From: Fiona Fitzgerald <Fiona.Fitzgerald@arun.gov.uk>
Sent: 31 March 2022 09:36
To: Michael Eastham <Michael.Eastham@arun.gov.uk>
Subject: RE: BE/20/22/DOC

Condition 4 – Lighting

Drawing Title:
**ELECTRICAL SERVICES
EXTERNAL LIGHTING LAYOUT**

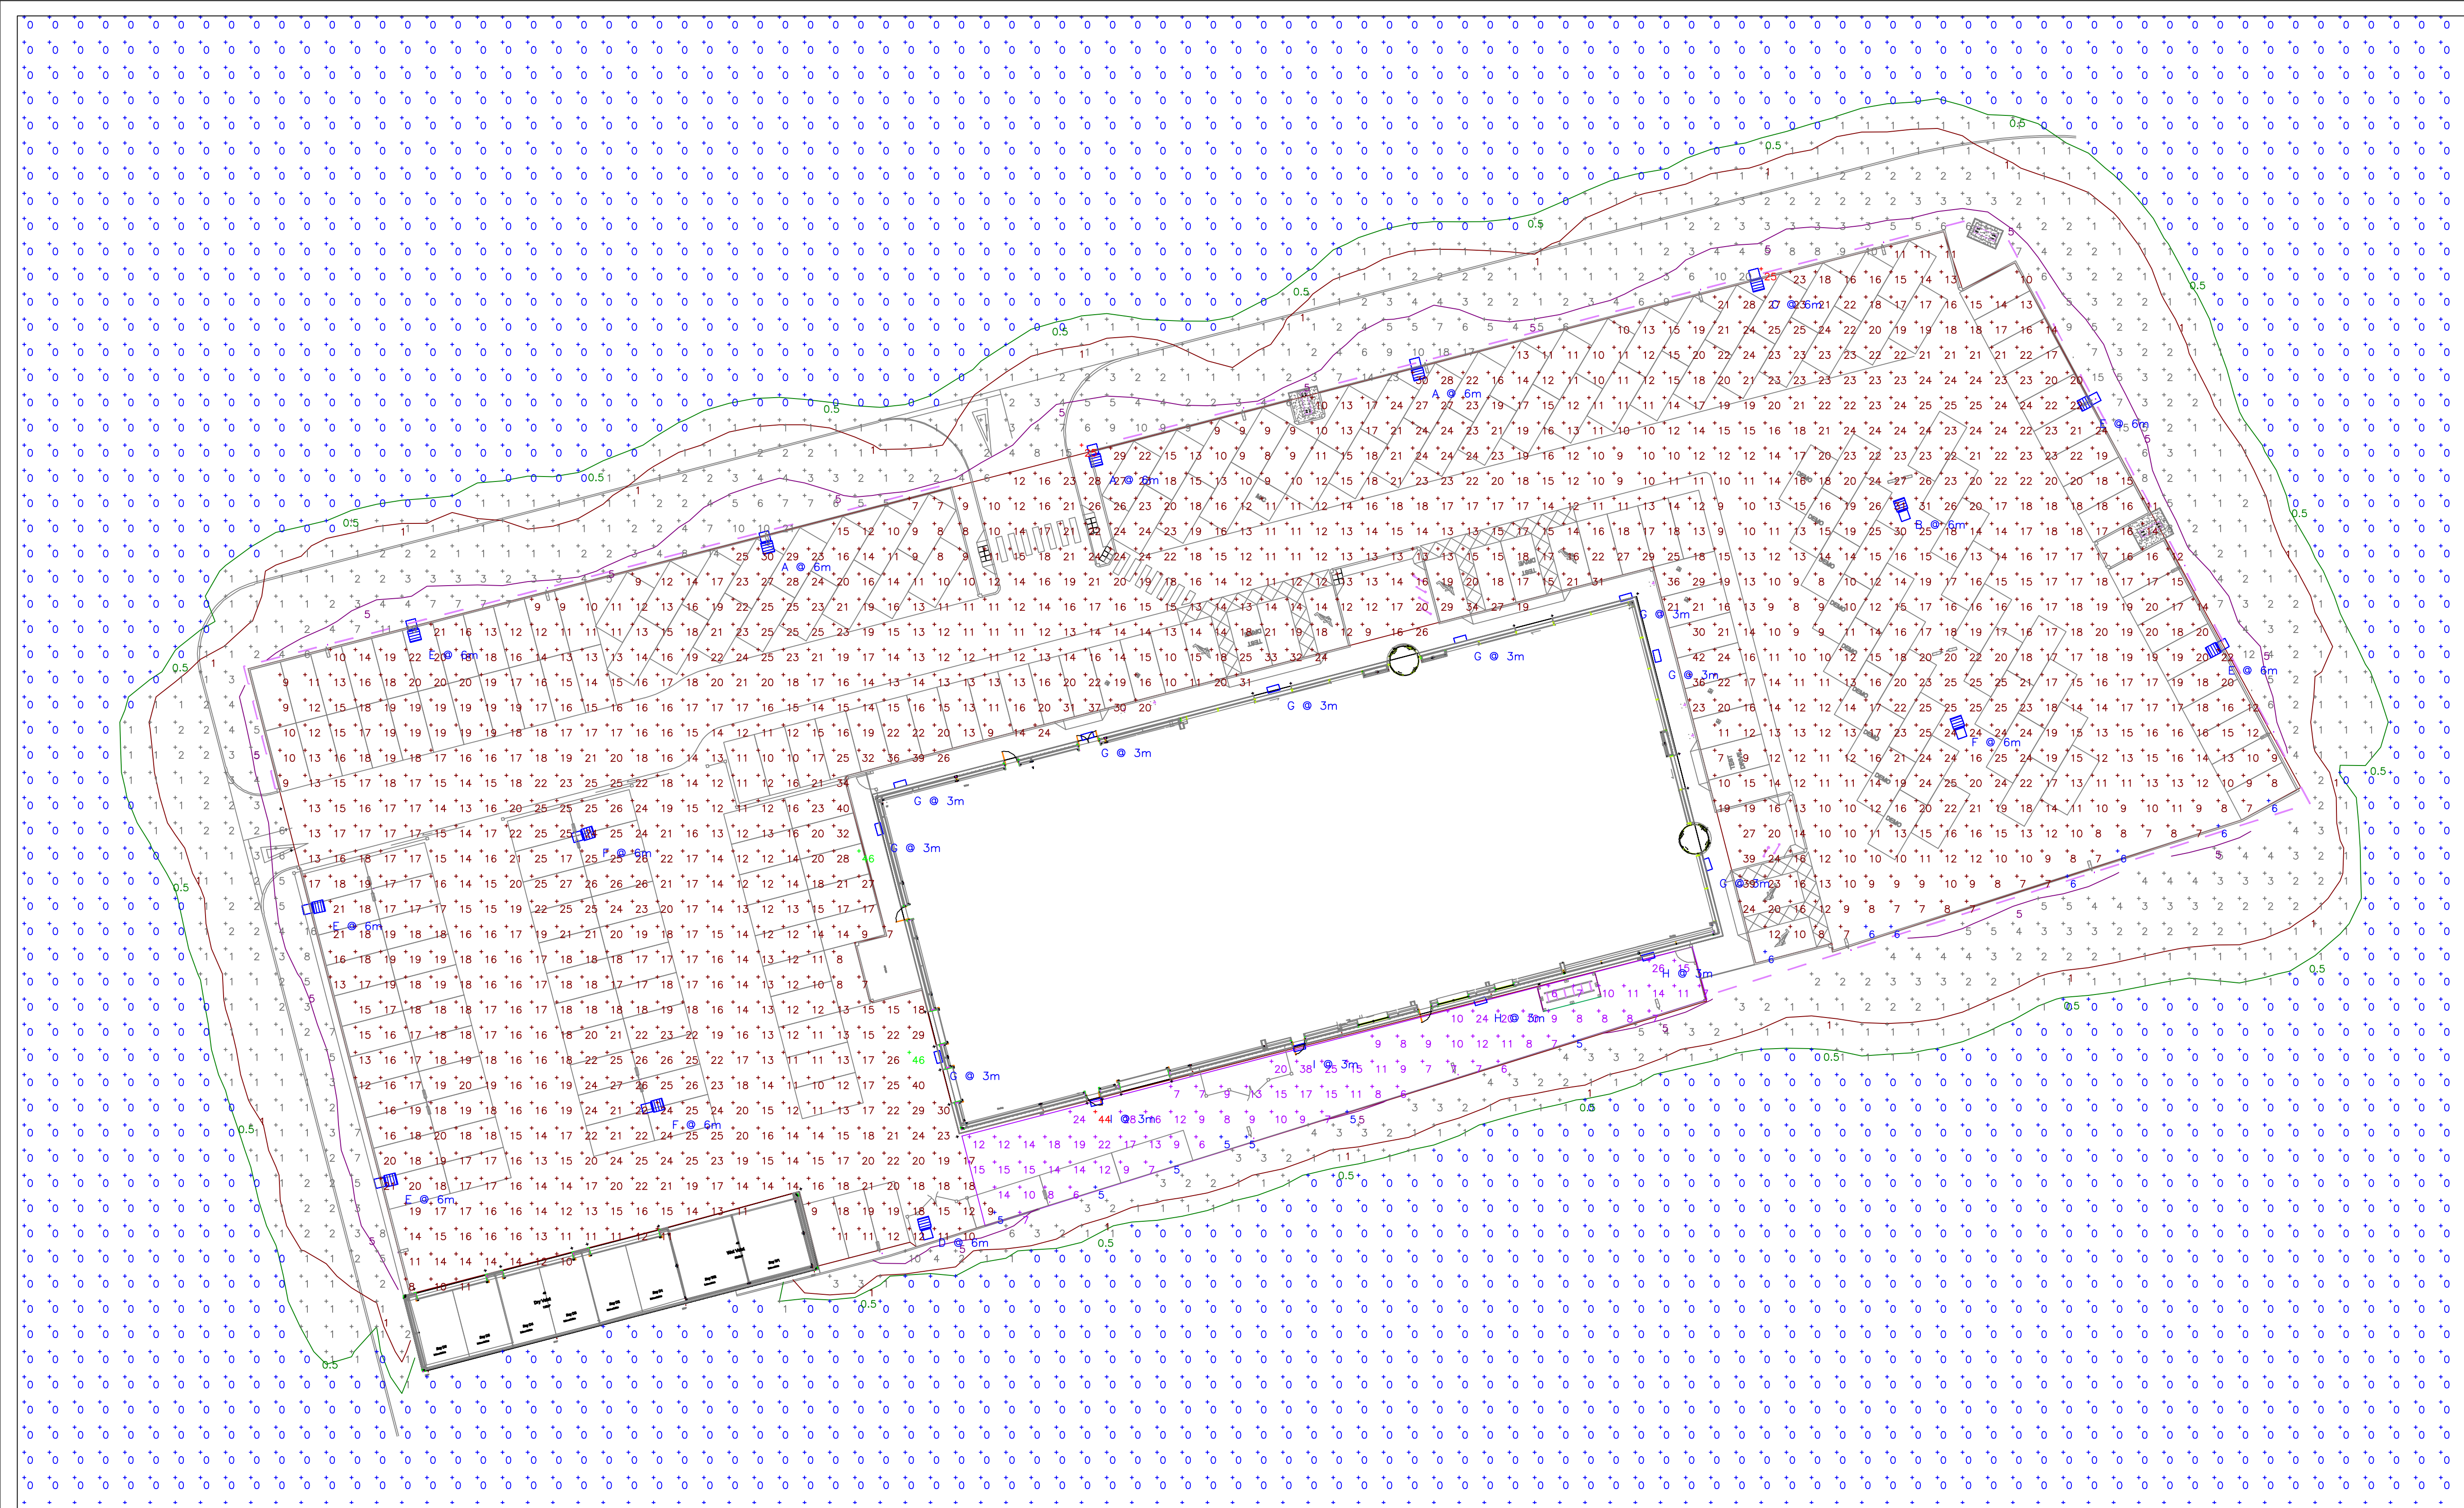
1. Please could the applicant confirm whether or not they have referred to (ILE) Guidance Note 1 for the reduction of obtrusive light 2021 as this does not appear to be stated in the Relevant Standards and Guidance section?
2. The document alludes to the fact that the scheme is consistent with Zone E2 but does not directly state it (last 2 paragraphs on page 5). Please could the applicant confirm whether or not the scheme complies with Zone E2 or not?

- The external lighting has been designed to ensure the reduction of obtrusive light is maintained across the site. This has now been added to the Relevant Standards and Guidance section.
- We can confirm that the external lighting has been designed to comply with Zone E2.
